Jeremy Smethurst WR summary, deadline 1

Please see attached my written representation for the 28th February deadline (deadline 1).

Rampion 2 Offshore Wind Farm  
Figure 26.8b Environment Agency Risk of Flooding from Surface Water Flood Extent: Washington

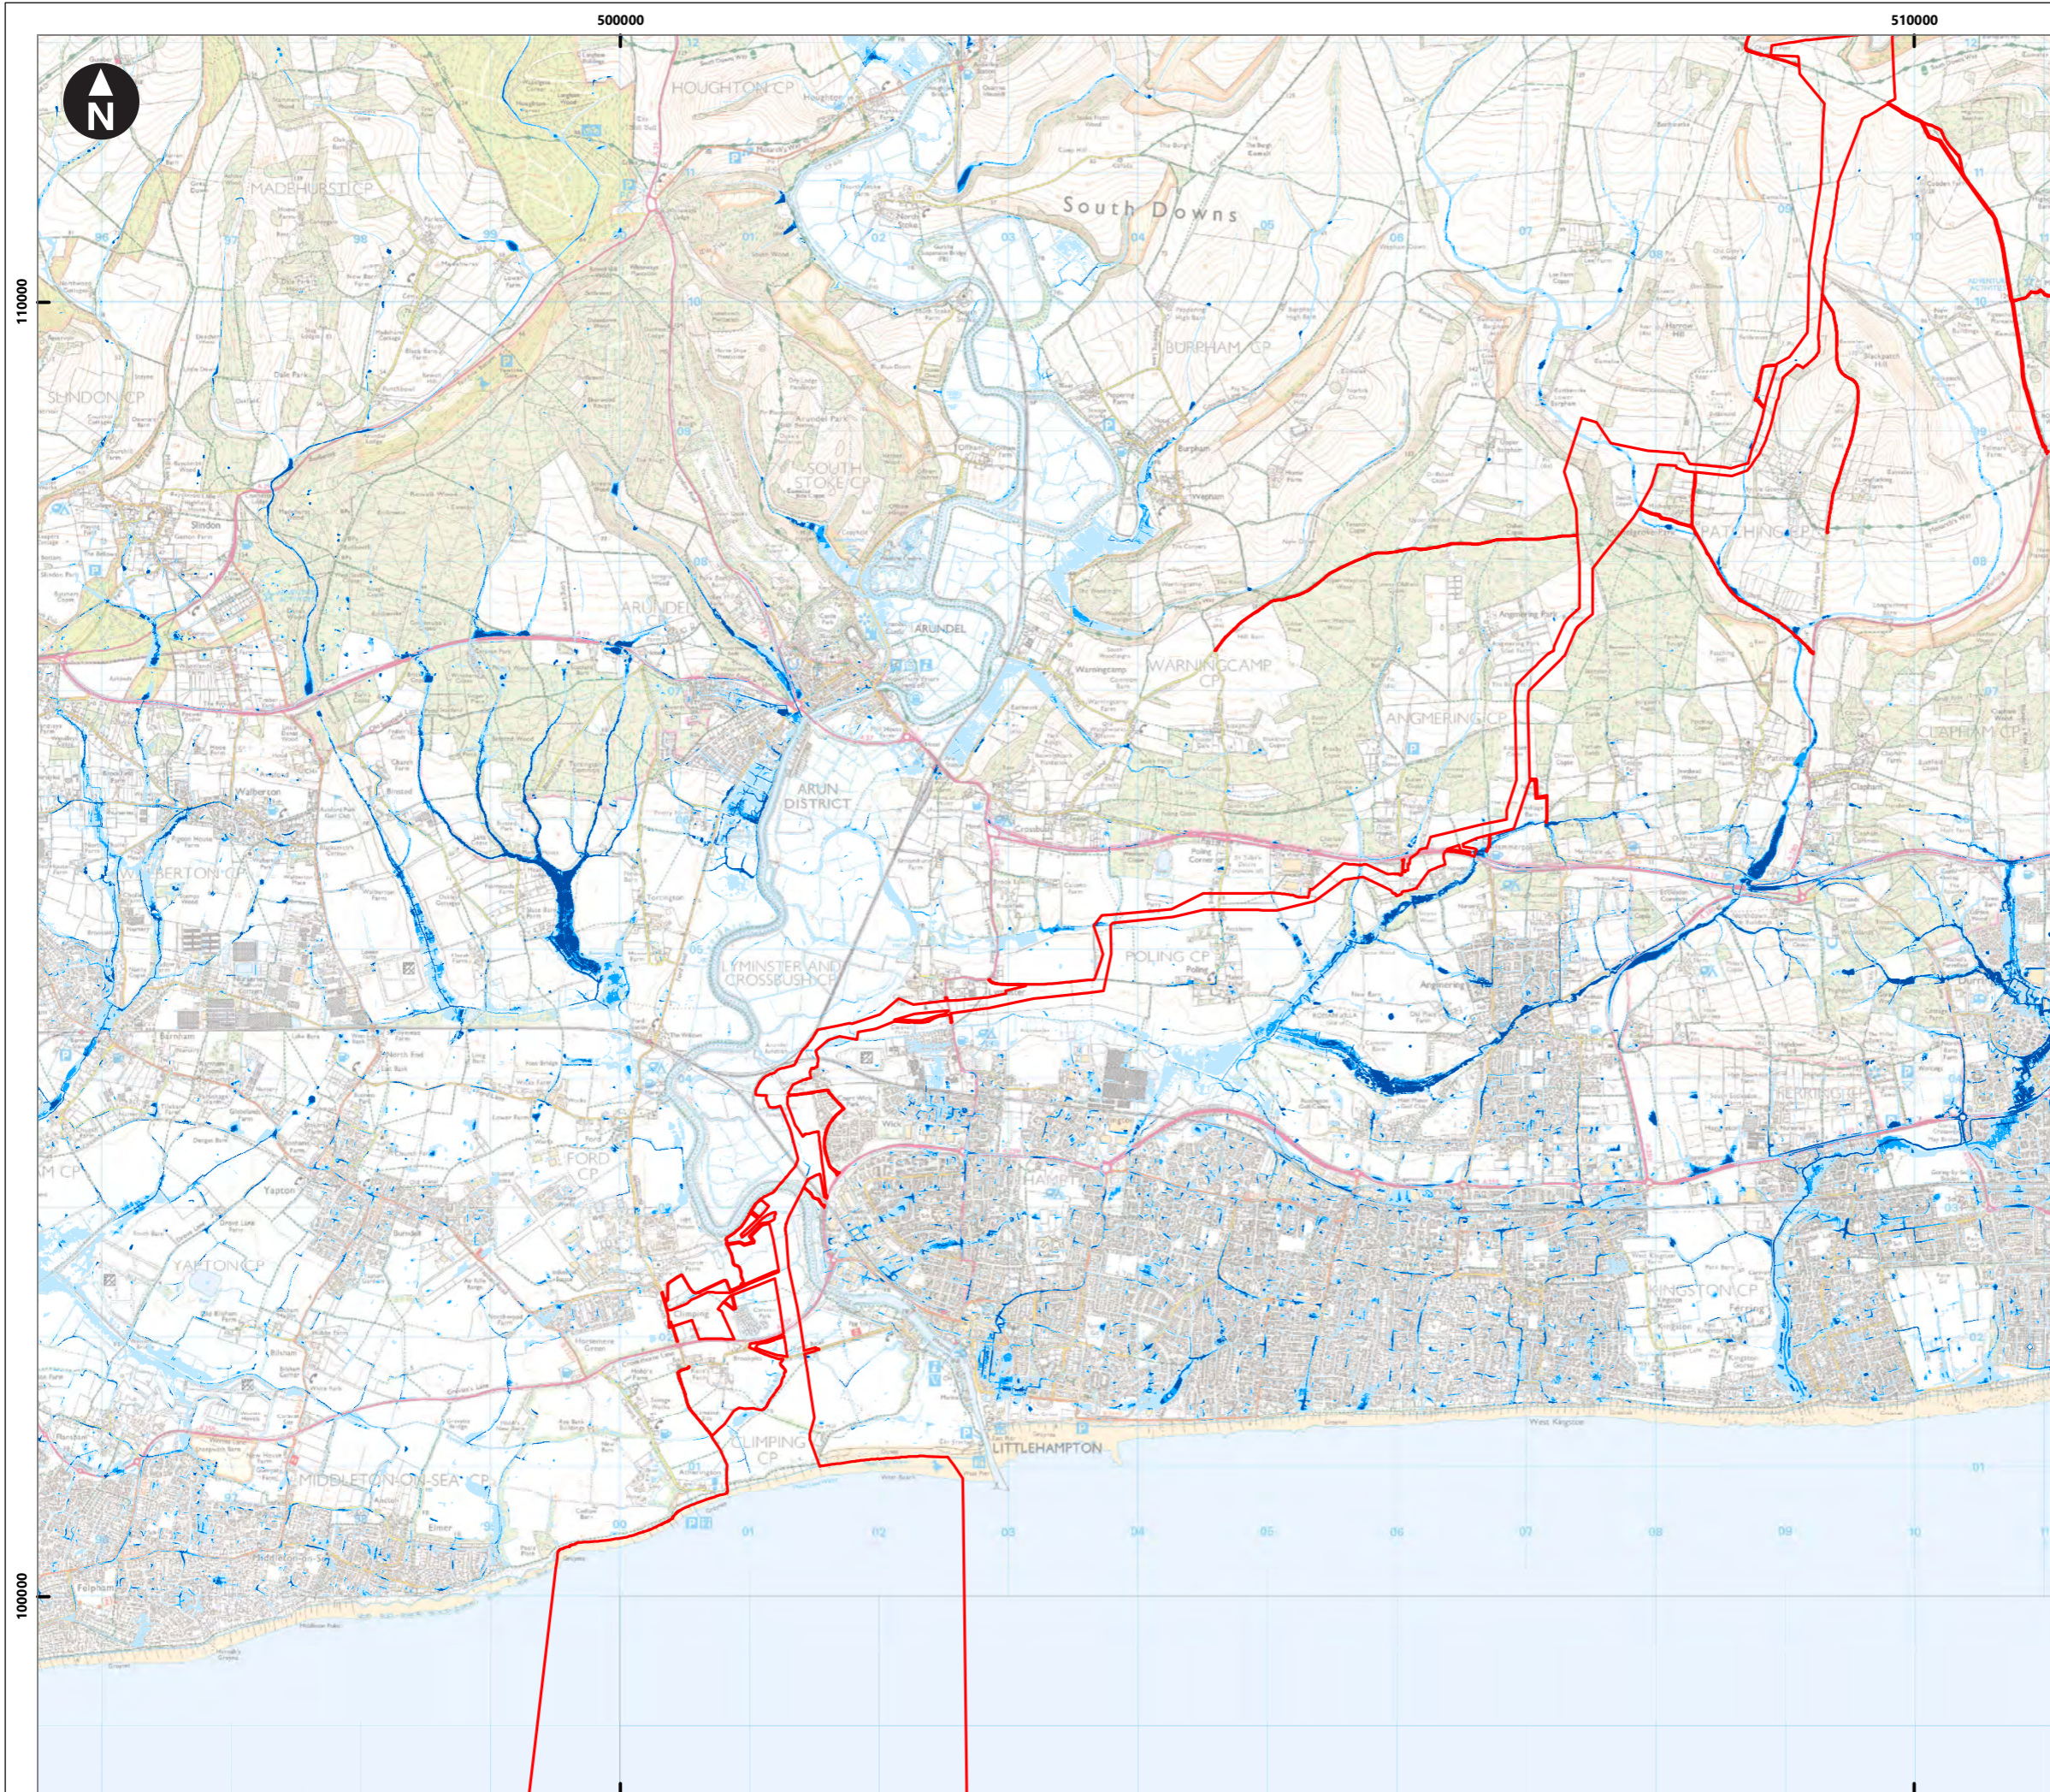
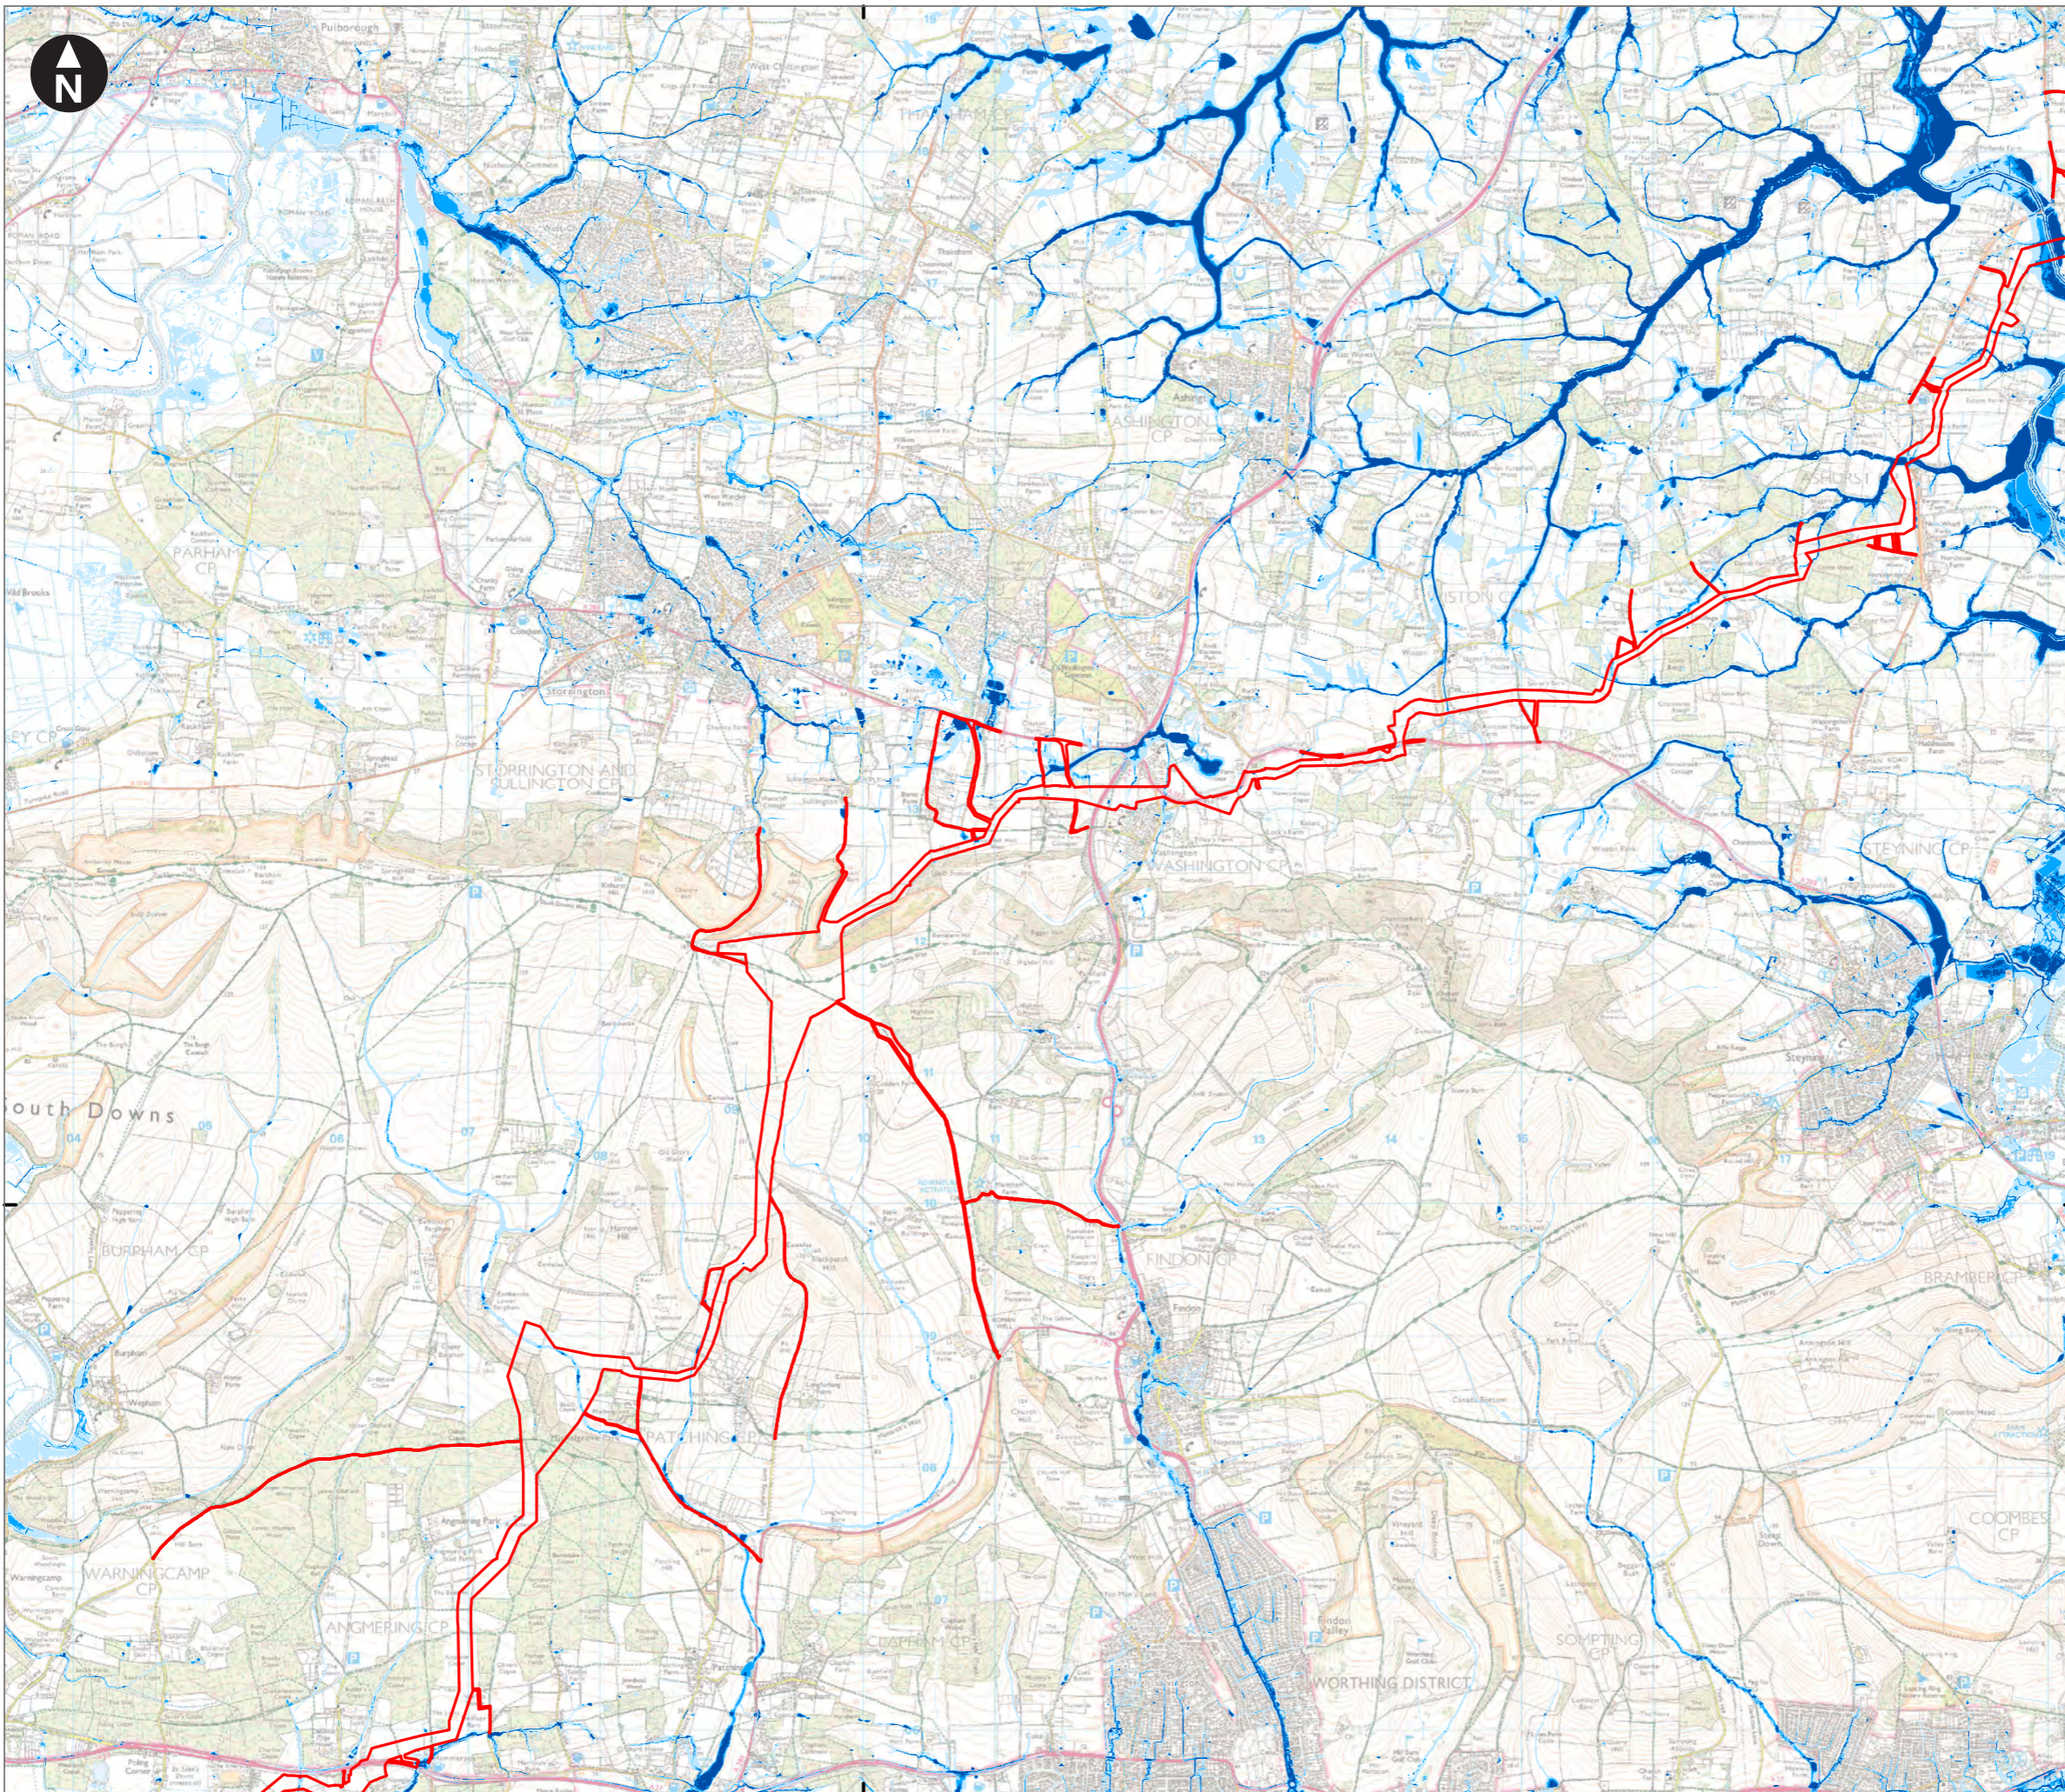
Indeed, their own map (Figure 26.2.6a) shows the risk of surface water flooding to be quite significant. Section 5.3, para 7-10 discusses the surface water flood risk on site. I dispute what is said in table 5-8; whilst this may be true for the whole Oakendene site, much of the highest risk areas ie 9,5% of the site, lies within the actual substation footprint (see map) There are too many 'it is thought that' statements-actual consultation would have cleared this up easily.

Yet even so, they admit in paragraph 6.5.3: *“Regions of high risk of surface water flooding are anticipated within the onshore substation footprint, coincident with several surface water flowpaths which drain from north to south across the site. In the absence of appropriate mitigation, aspects of the onshore substation and associated infrastructure may be at risk of flooding from both surface water run-on and run-off.”* However, their Outline Drainage Plan does not adequately address this.
